From: Richard Castro-Parker
Sent: 30 August 2019 12:03
To: Laura Gibbons
Cc: Daniel Vick
Subject: RE: BE/139/18/PL - Innovation Centre Beeding Close

Please see the attached PDFs of the drainage layout plan for the site re: BE/139/18/PL - Innovation Centre Beeding Close. Please could you comment on these and whether they deal with the matters you have previously raised.

- Proposed Drainage Layout – 1:100 Scale;
- Proposed Drainage Layout – 1:400 Scale.

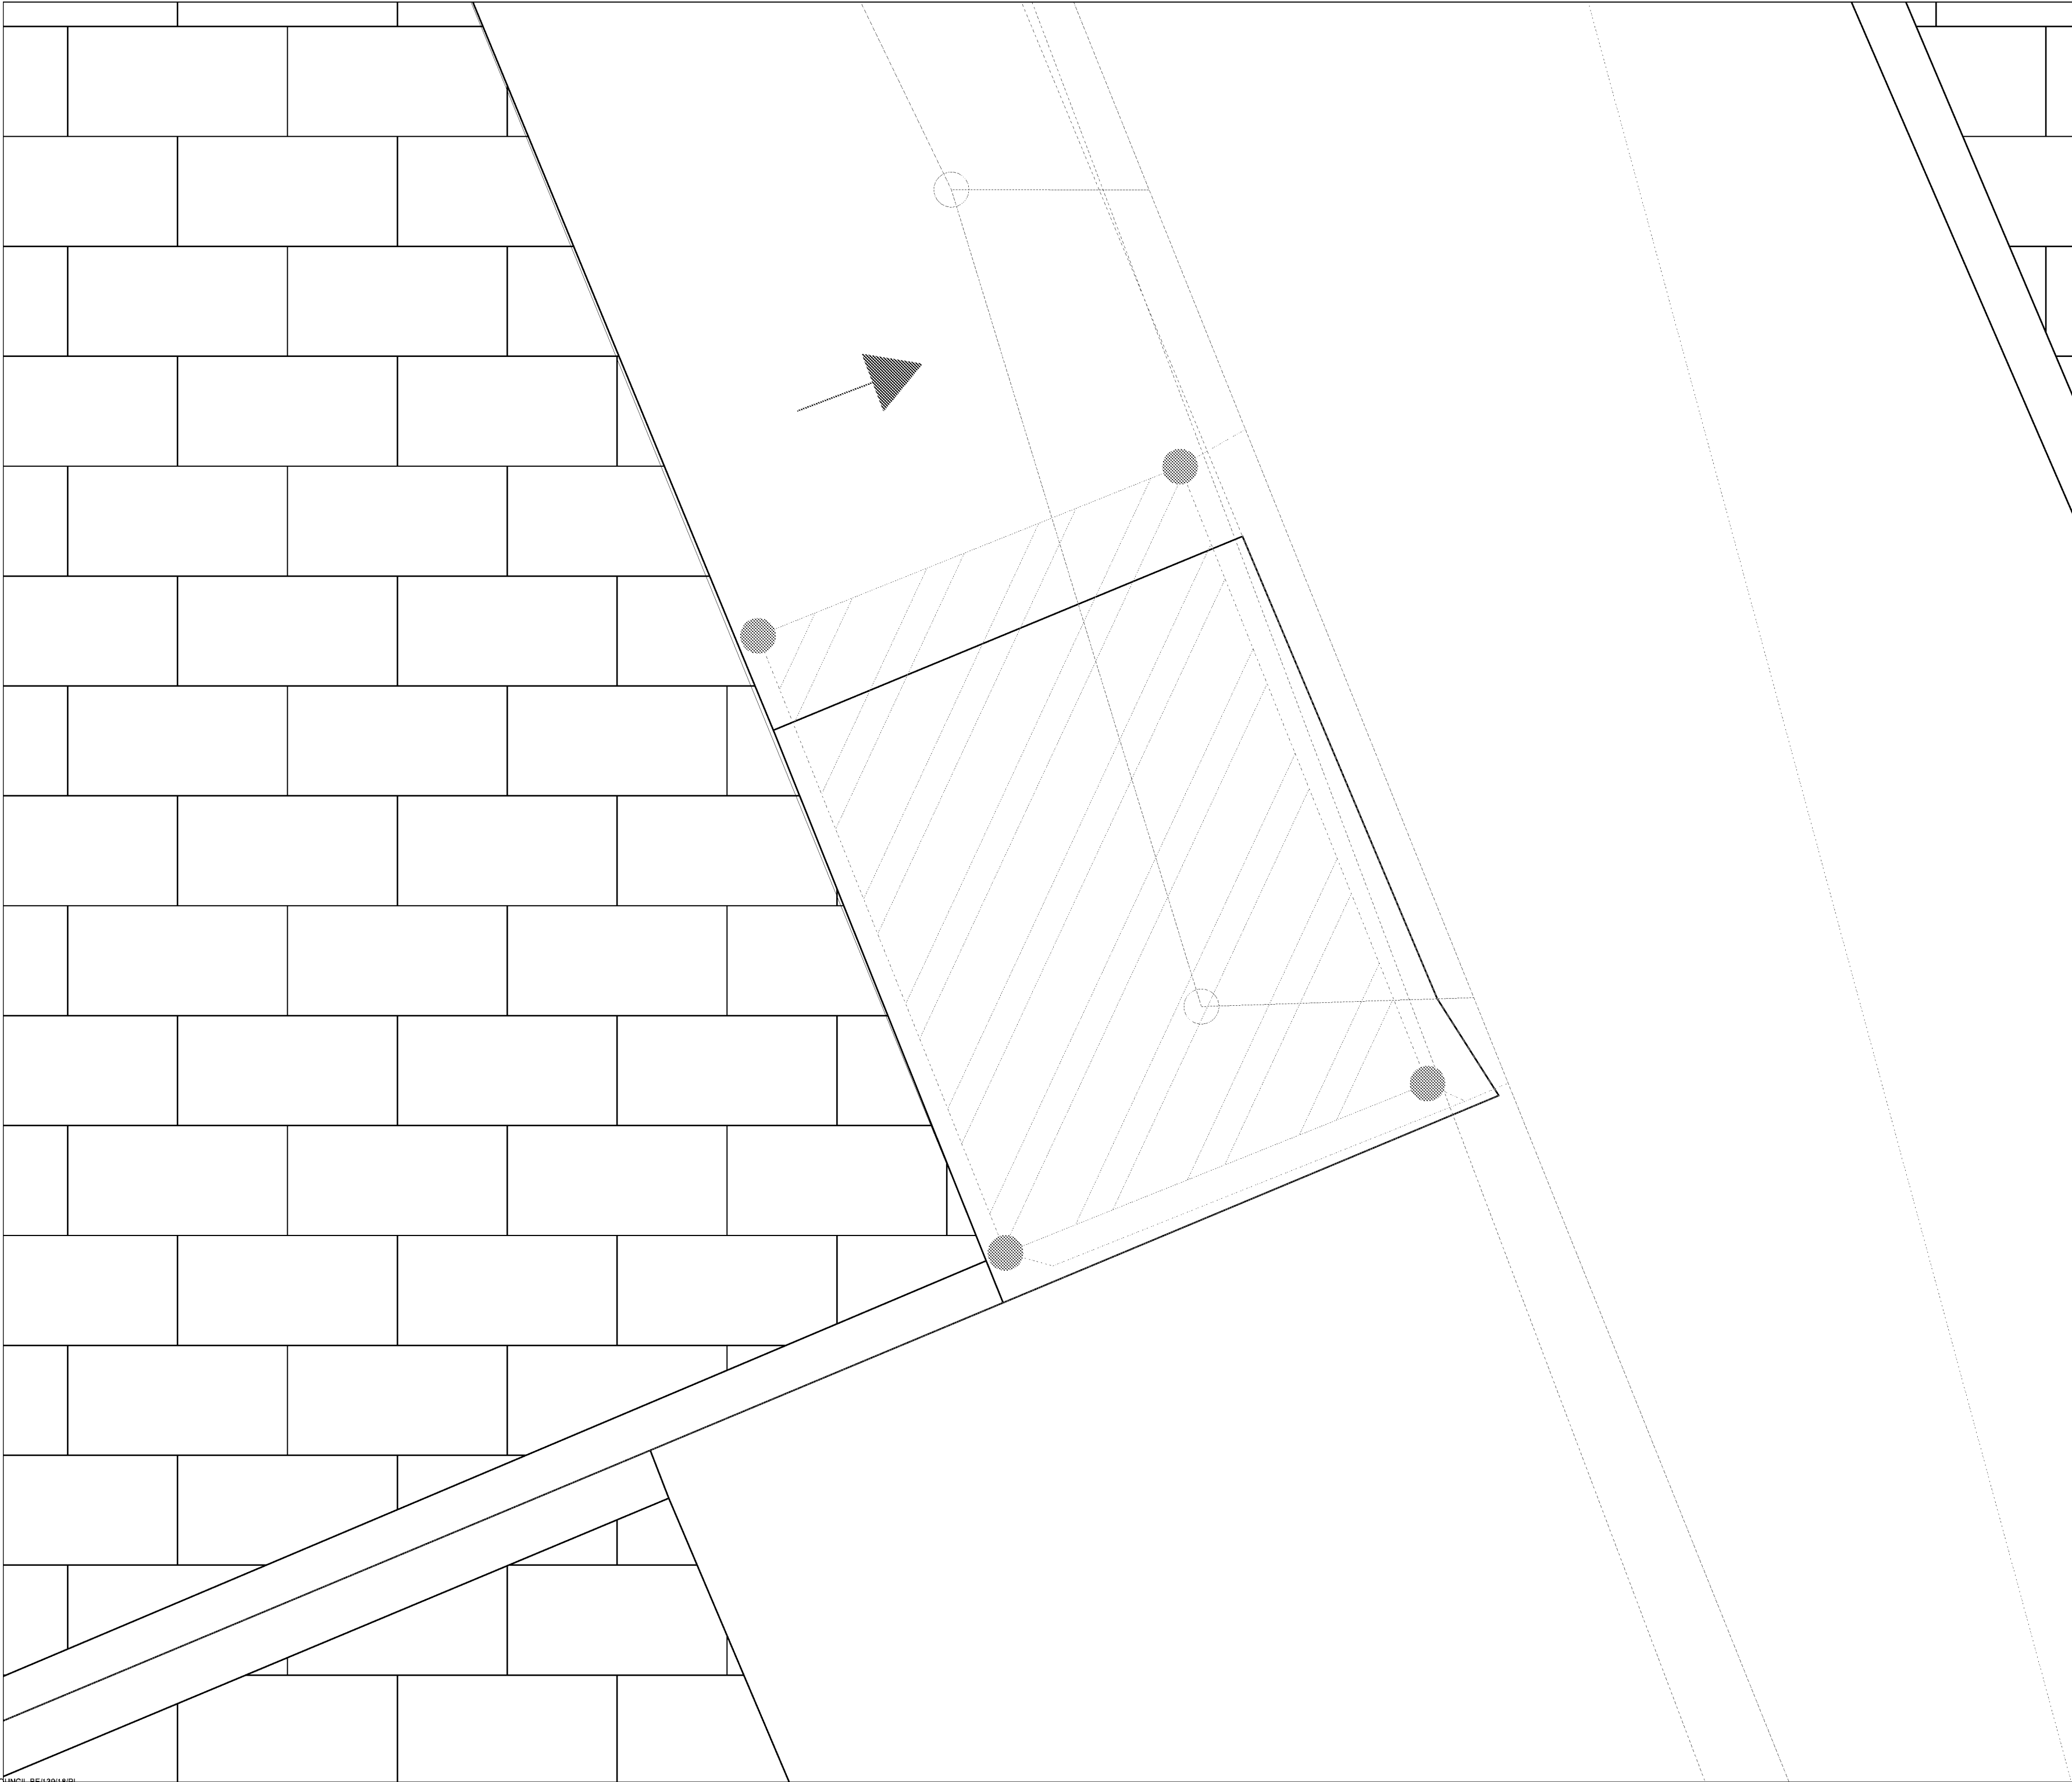
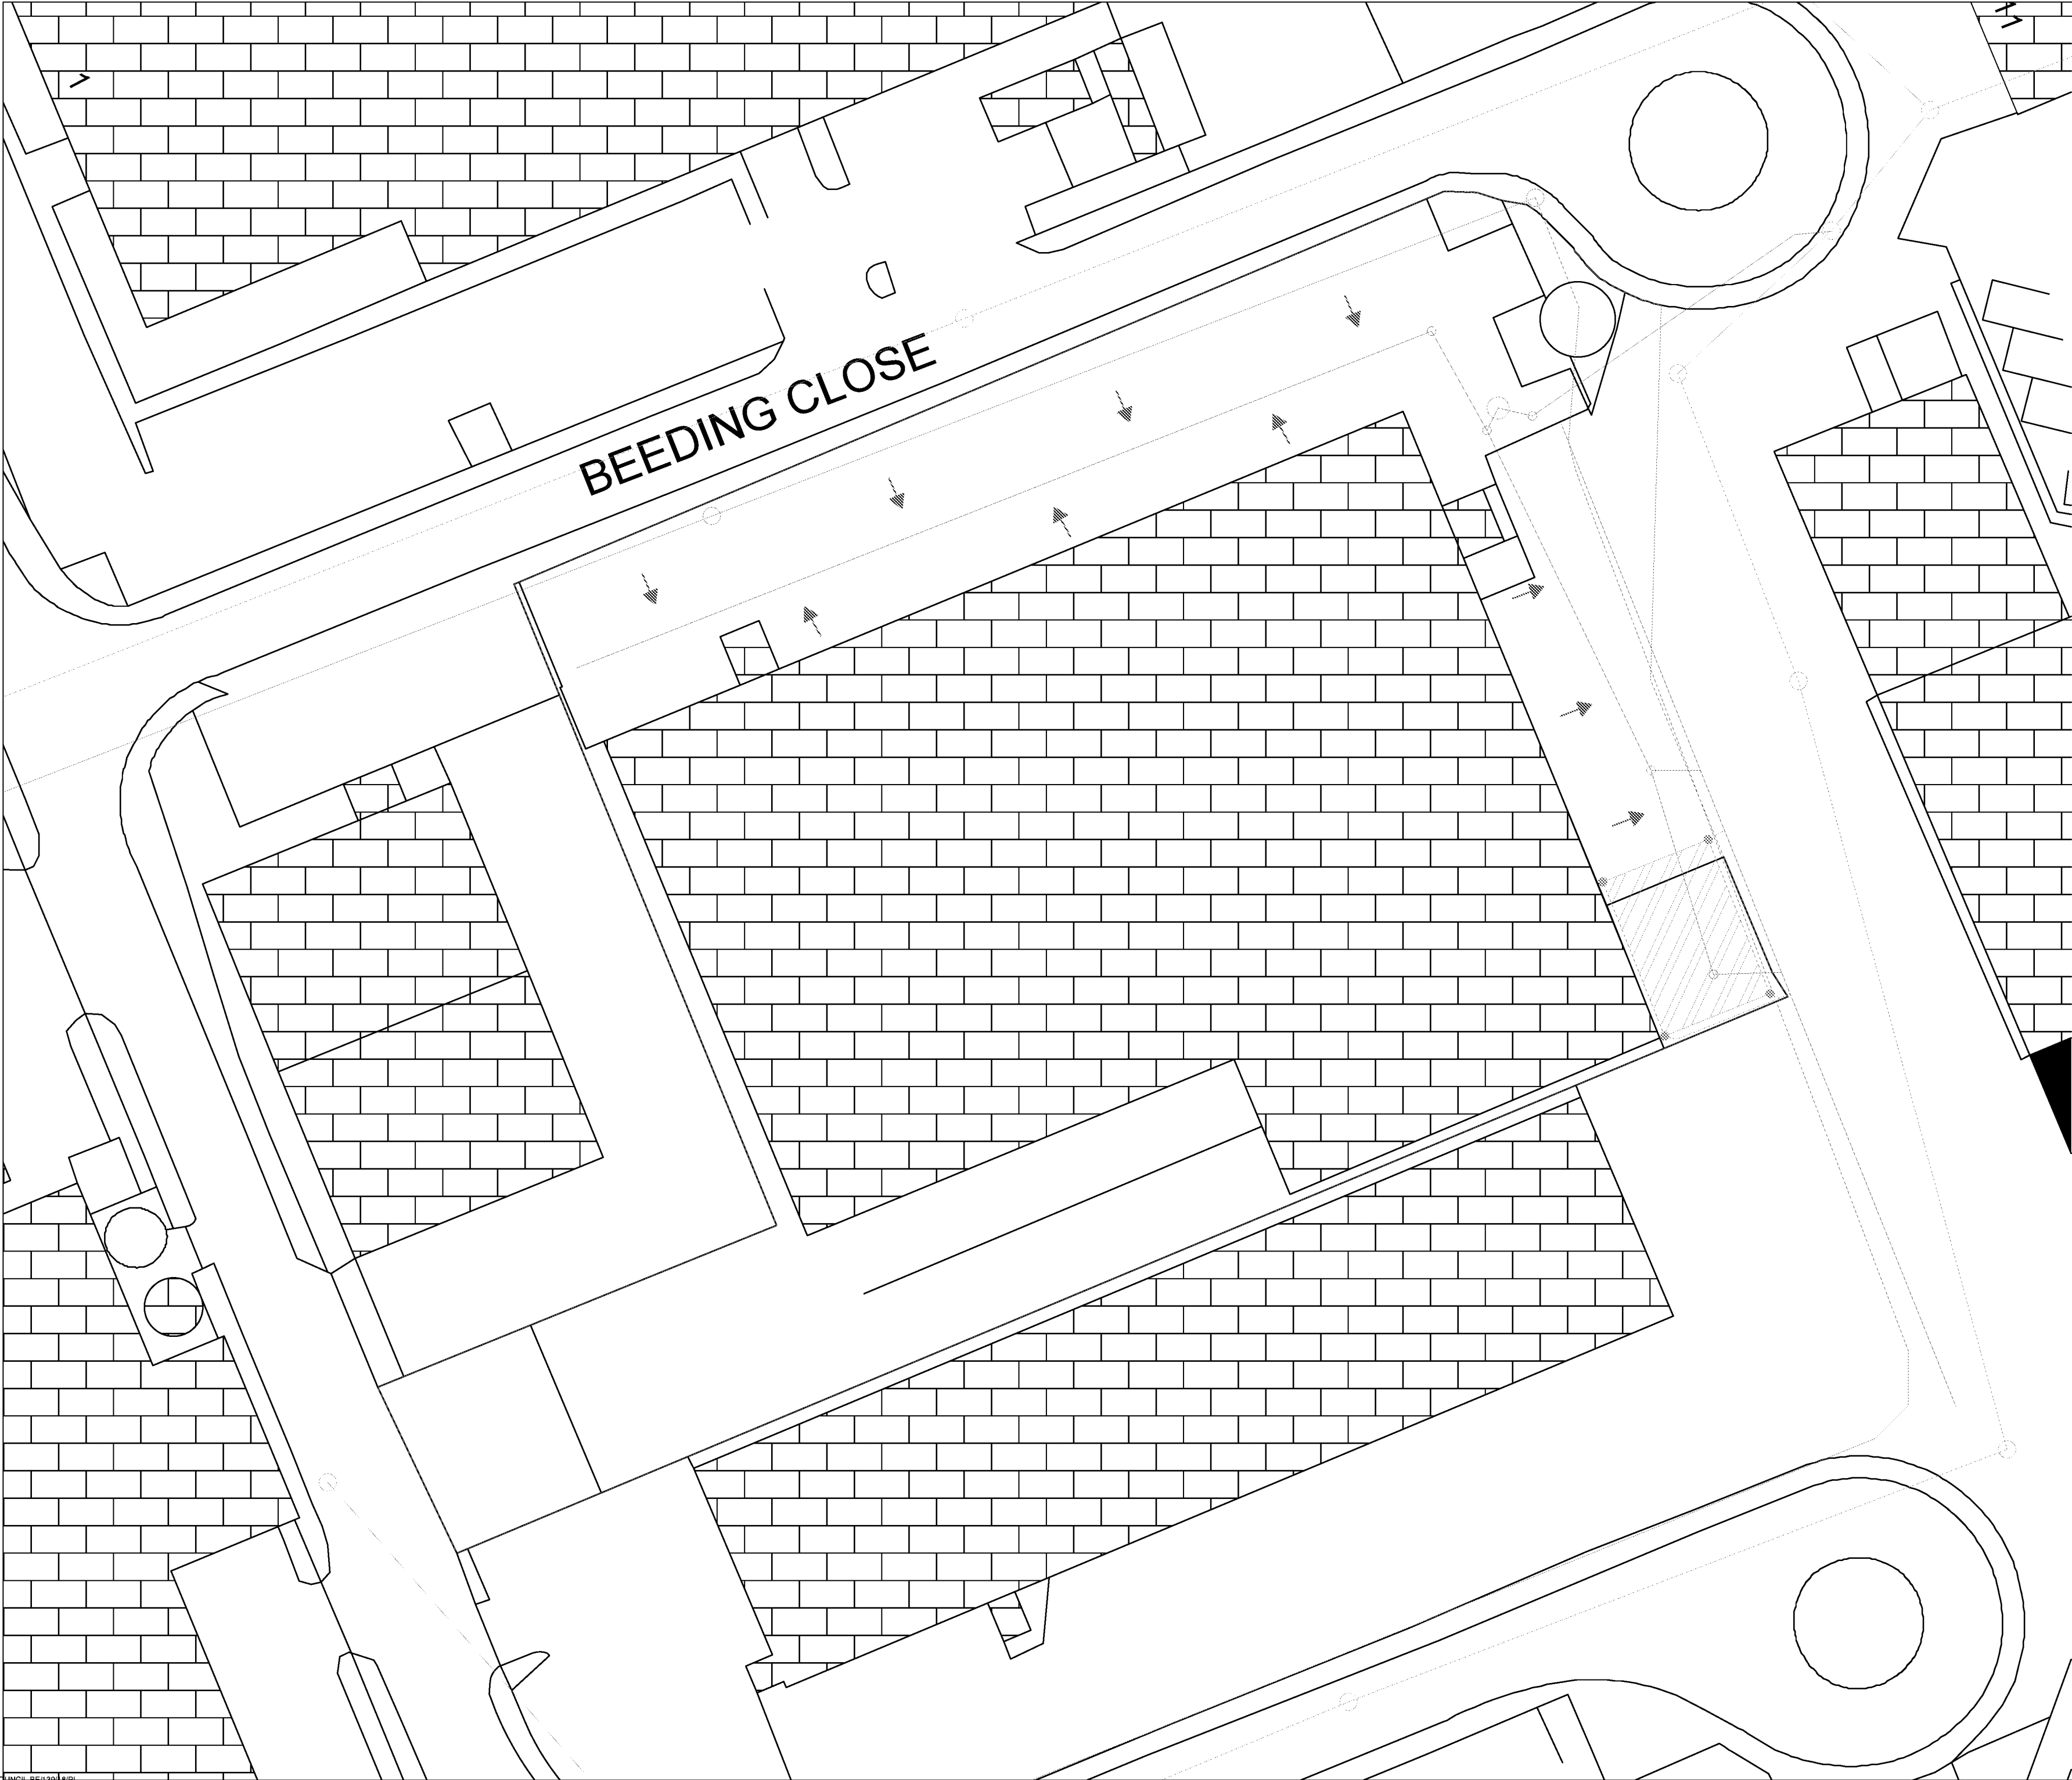
I still am struggling to distinguish between lines. Please can different line types be used, rather than all very similar colours. Please can gullies, manholes, and linear drainage channels be clearly labelled.

Regarding the levels, I also requested some spot levels of the surrounding land, can these be provided. This is fundamental to ensure that the surface water from the development does not go off site.

Please can the applicant submit clearer plans of the proposed surface water drainage arrangement. I.e. different line types used, rather than all very similar colours. Please can gullies, manholes, and linear drainage channels be clearly labelled.

I also require levels to be submitted showing invert and cover levels of the existing drainage network and spot levels of the surrounding land. This is fundamental to ensure that the surface water from the development does not go off site.

Please find attached a PDF of the drainage layout plan for the site. Given the size of the site, all lines on the plans are small. However, if Laura zooms in she will be able to distinguish between the pipes types. This should hopefully address her first concern.

With regards to levels, having reviewed the sewer asset location search requested from Southern Water, both invert and cover levels for all Southern Water manholes are detailed within their response. A copy of the sewer asset location search was included within the appendix of the Surface Water Drainage Strategy – this have been attached to this email for her reference.
